From: Zac Denton
Sent: 25 July 2019 09:34
To: Planning Scanning
Subject: FW: Mistletoe Farm, Horsemere Green Lane. CM/13/19/RES; Revised Drainage Proposals
Attachments: RE: Mistletoe Farm, Horsemere Green Lane. CM/13/19/RES; Revised Drainage Proposals

From: Laura Gibbons
Sent: 24 July 2019 12:40
To: kazys [REDACTED]
Cc: Edward Rees <[REDACTED]>, Zac Denton <[REDACTED]>
Subject: RE: Mistletoe Farm, Horsemere Green Lane. CM/13/19/RES; Revised Drainage Proposals

I have considered both the proposed drainage strategy (Escher Silverman, dwg.no. 602-04, Rev B) and Tree Retention & Protection Plan (Lizard, dwg.no. LLD1394-ARB-DWG-002, Rev 01) alongside one another, to understand the likely impact on retained trees.

Tree Retention & Protection Plan

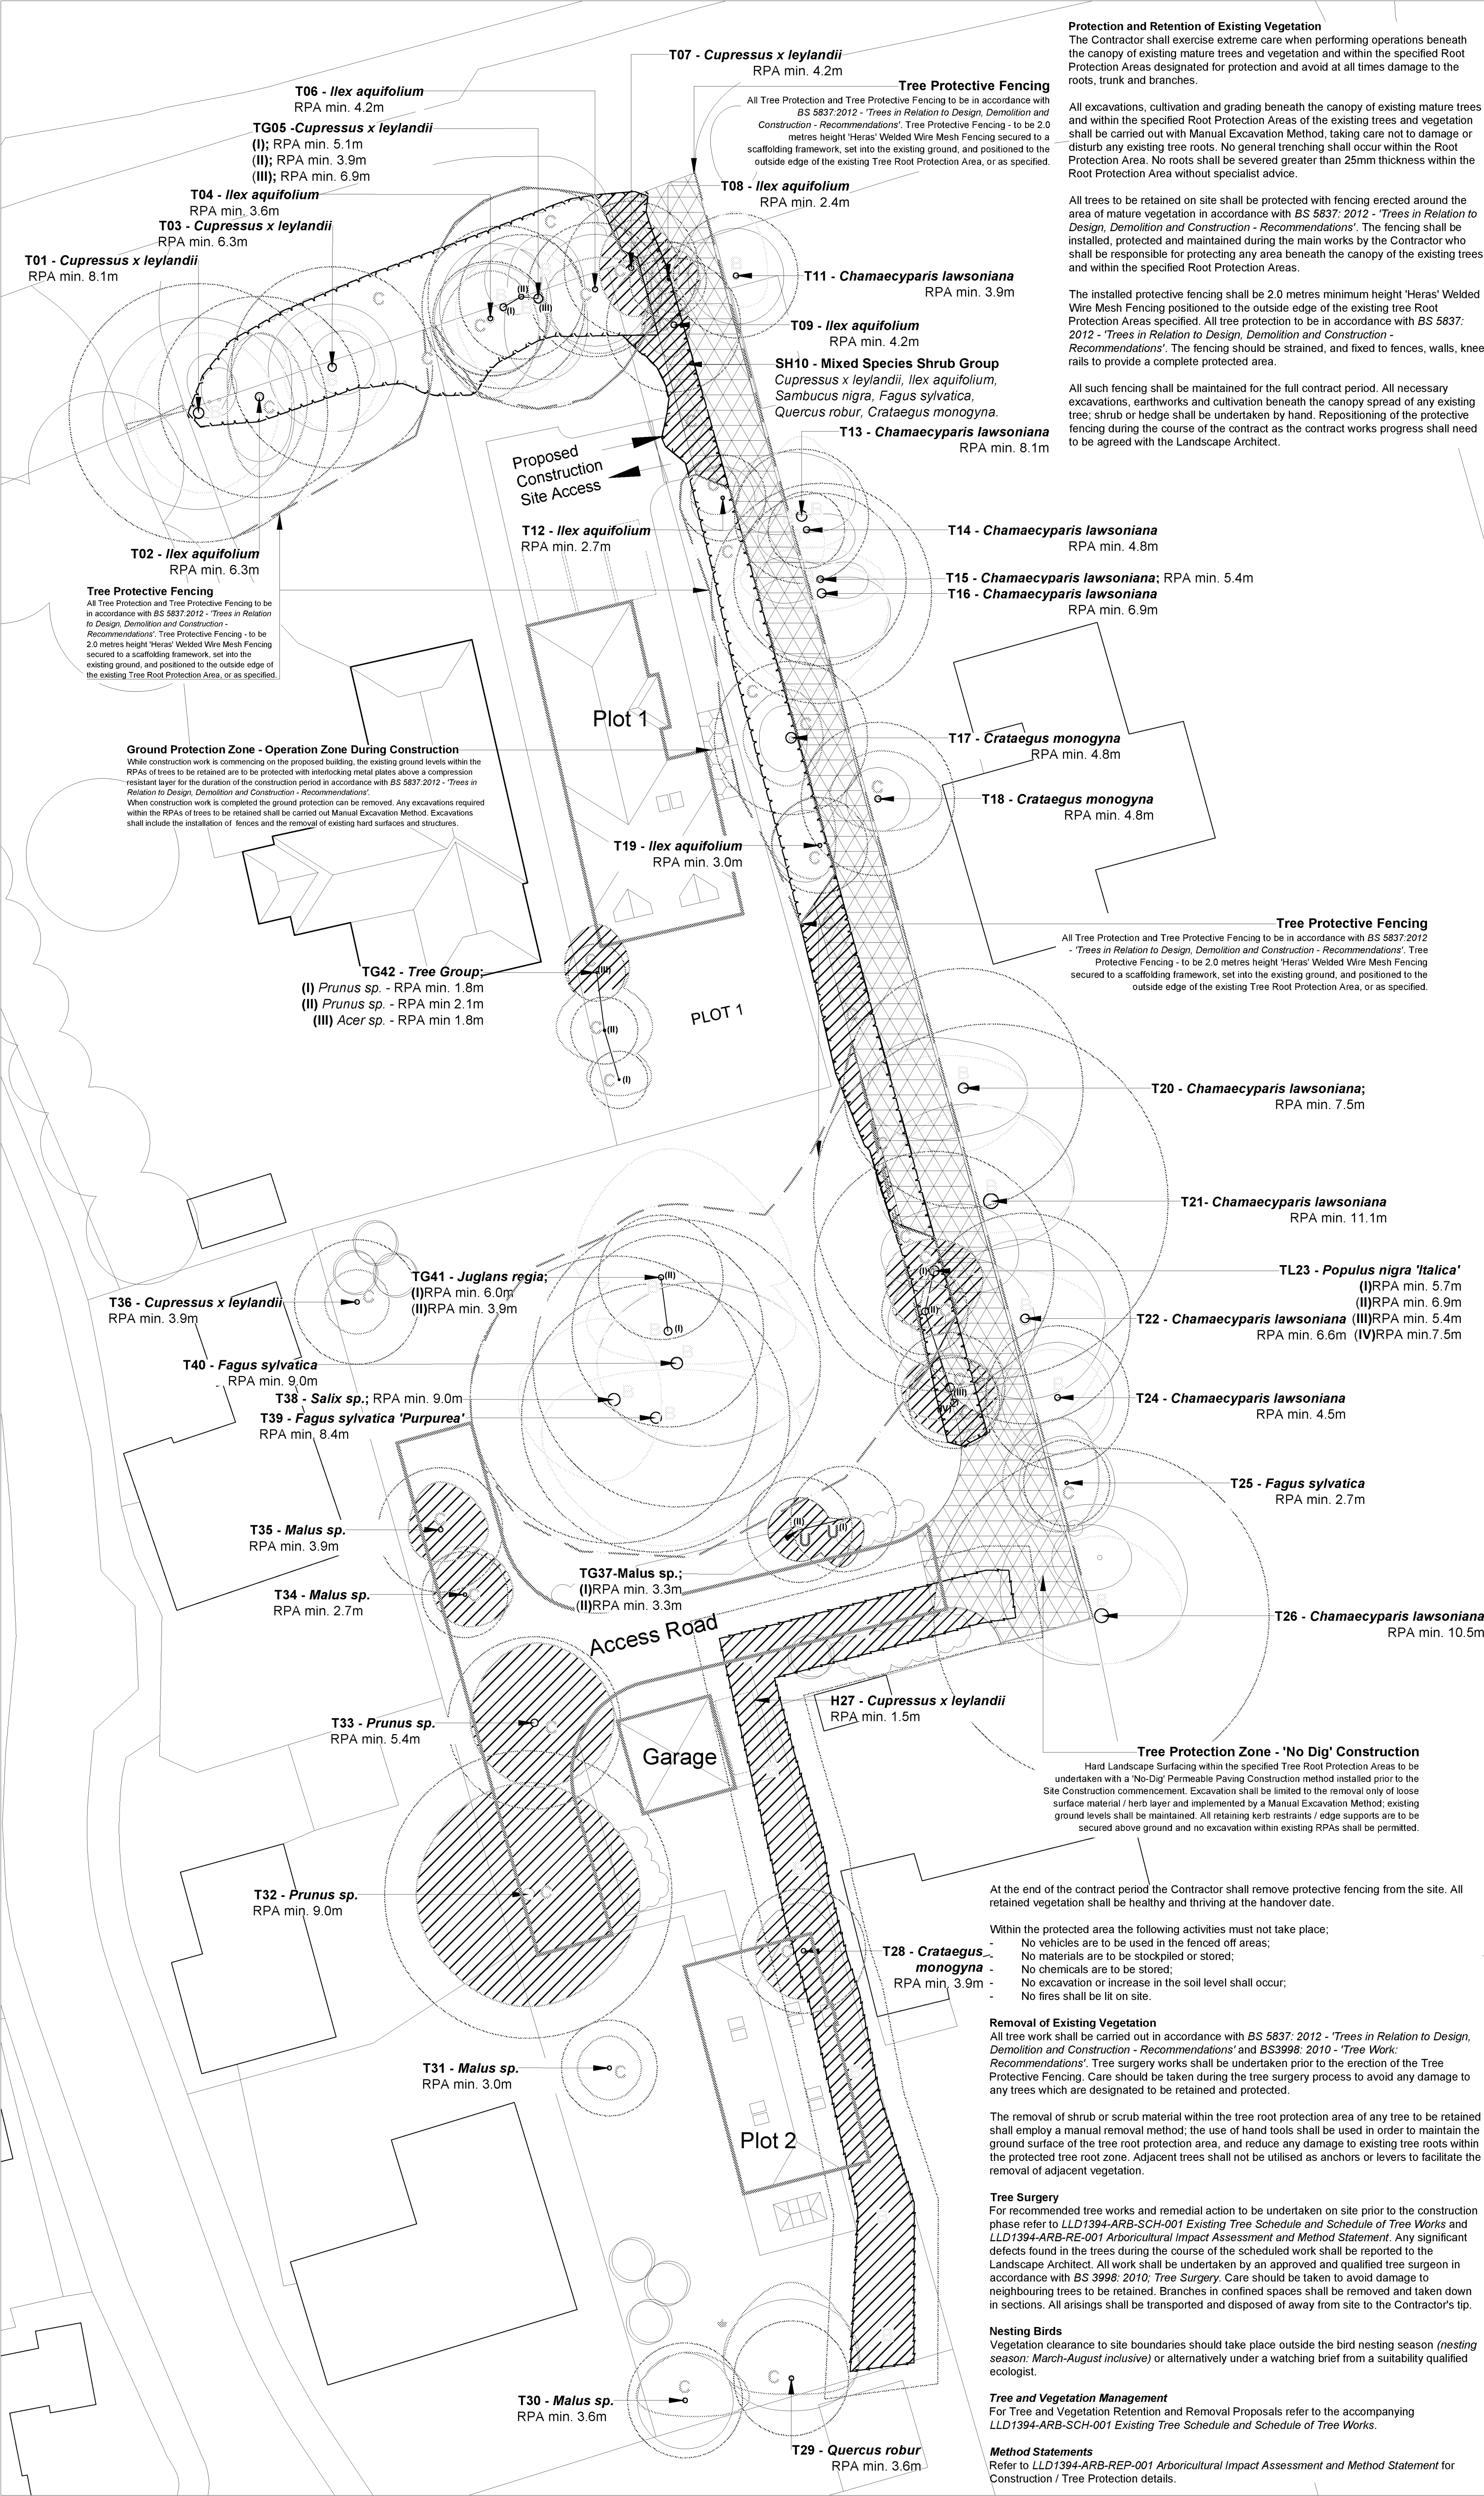
I have estimated the lateral extent of Root Protection Area (RPA) incursion required to implement the swale, as follows:

T36 Leyland cypress (Cat C) – Proposed for retention and not at risk from current swale proposal. Could be sacrificed with no significant loss of visual amenity (to facilitate an alternative scheme?).

T38 Willow (Cat B) – Approx. 7m encroachment into 9m RPA.

T39 Beech (Cat B) – Approx. 4m encroachment into 8.4m RPA.

T40 Beech (Cat B) – Approx. 4m encroachment into 9m RPA.

T41 2x walnut (?) – Approx. 1.5 & 2m encroachment into 4m and 6m RPA.

TG42 Mxd. *Rosaceae* (Cat C) – 1 of 3 trees already identified for removal. It looks like the other two trees will have to be sacrificed to implement subterranean elements of the scheme.

For all those trees highlighted in bold text, the RPA incursion is damaging to an extent far beyond that which is required to guarantee their long-term survival. This group represent the most significant arboricultural feature on the site, which the LPA have recognised by identifying the central beech tree (T40) for preservation (TPO) and seeking a revised plot layout that also allows for successful retention of its companion trees.

I would be prepared to accept the loss of some trees in the group (T38, T41) and outlier (T36) to accommodate a swale (if no reasonable and practical alternative exists) – but the RPA of T39 and T40 should remain sacrosanct. Ideally we should seek to have RPAs of all those trees (in bold type) left unaltered.

In conclusion, I find the proposed location for the swale to be wholly unacceptable and would expect the applicant/agent to provide an alternative scheme that meets with your requirements and fully respects T38 – T41 incl. or consider an alternative site layout.

Drawing Title				
Engineering Details Drainage Strategy (with Ditch)				
Drawn	Checked	Scales	Paper Size	Date
KN		1:250	A1	07.19
Job No.	Drawing No.	Revision		
ES1820	602-04	C

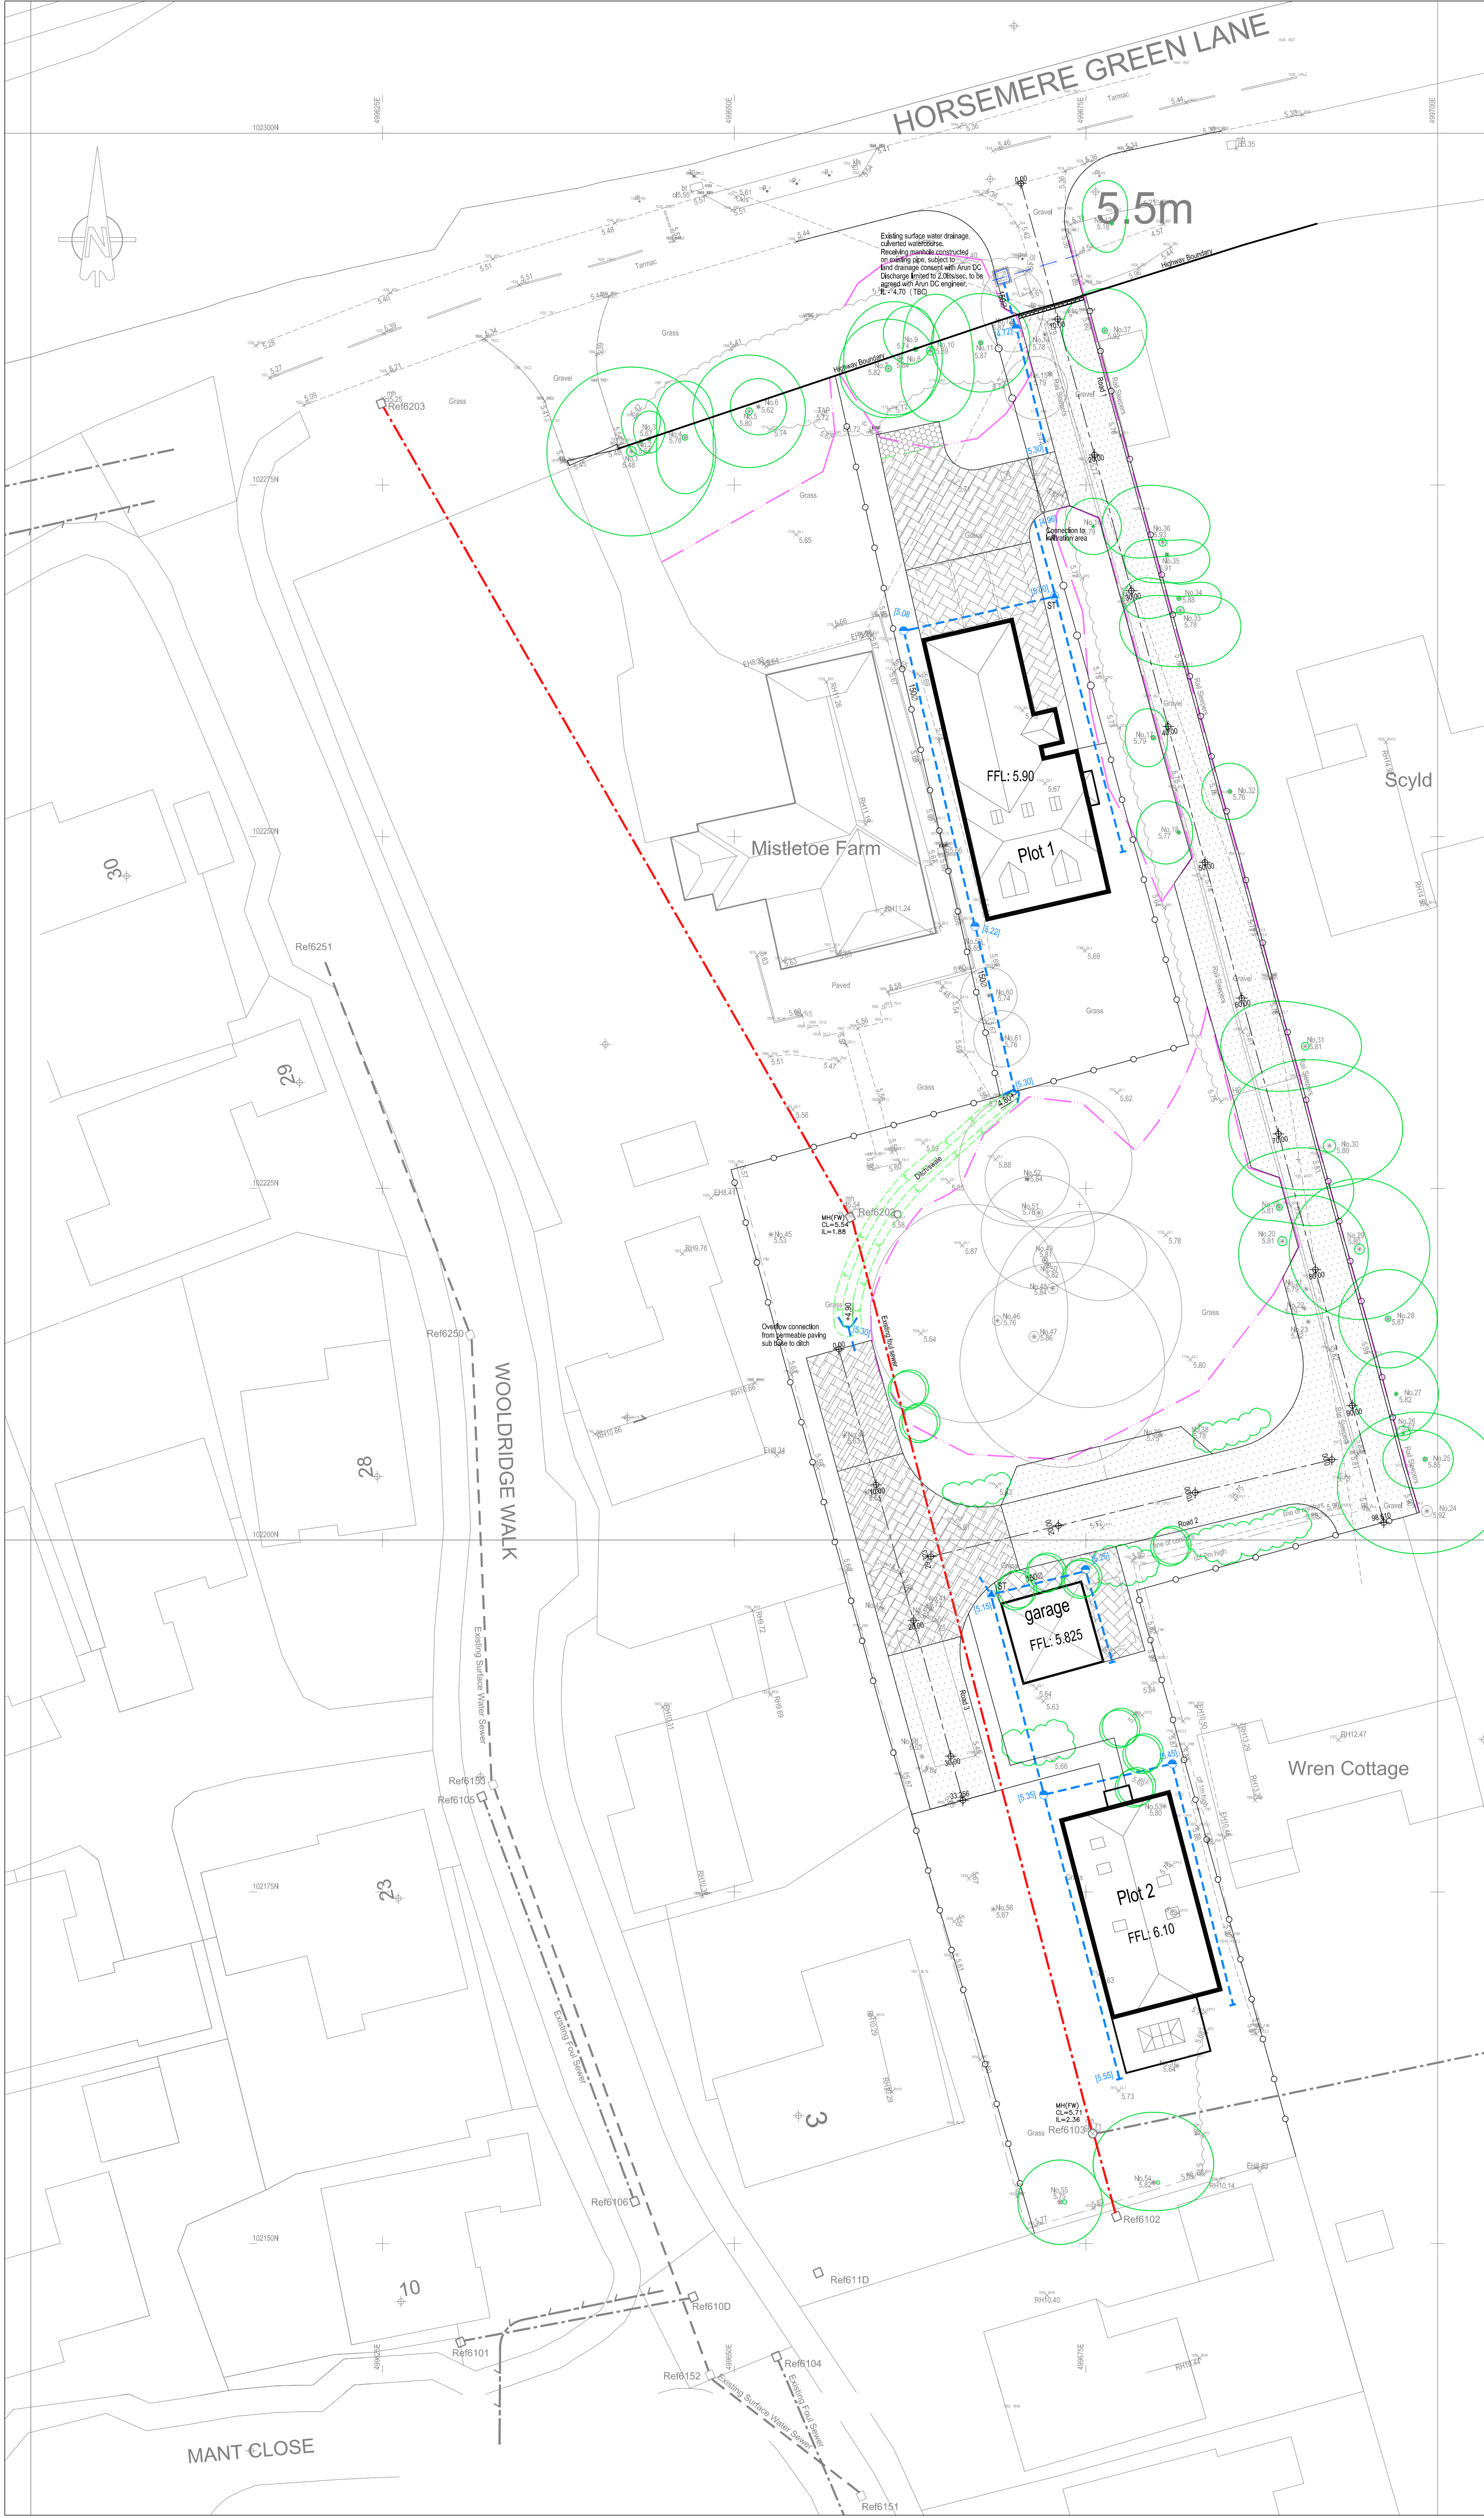
I have now received feedback from our tree officer, to quote his summary "I find the proposed location for the swale to be wholly unacceptable and would expect the applicant/agent to provide an alternative scheme that meets with your requirements and fully respects T38 – T41 incl. or consider an alternative site layout." His full response is attached.

I wonder if the swale could be located outside of the RPAs. Could you look at extending the permeable paving further north and forming the outlet to the swale here, and maybe sweeping round to the downstream pipe connection?

The permeable paving for plot 2 looks like it could only be located in the T furthest round on the road rather than at the junction of roads 1 and 2. The swale also appears to be within a no dig area.
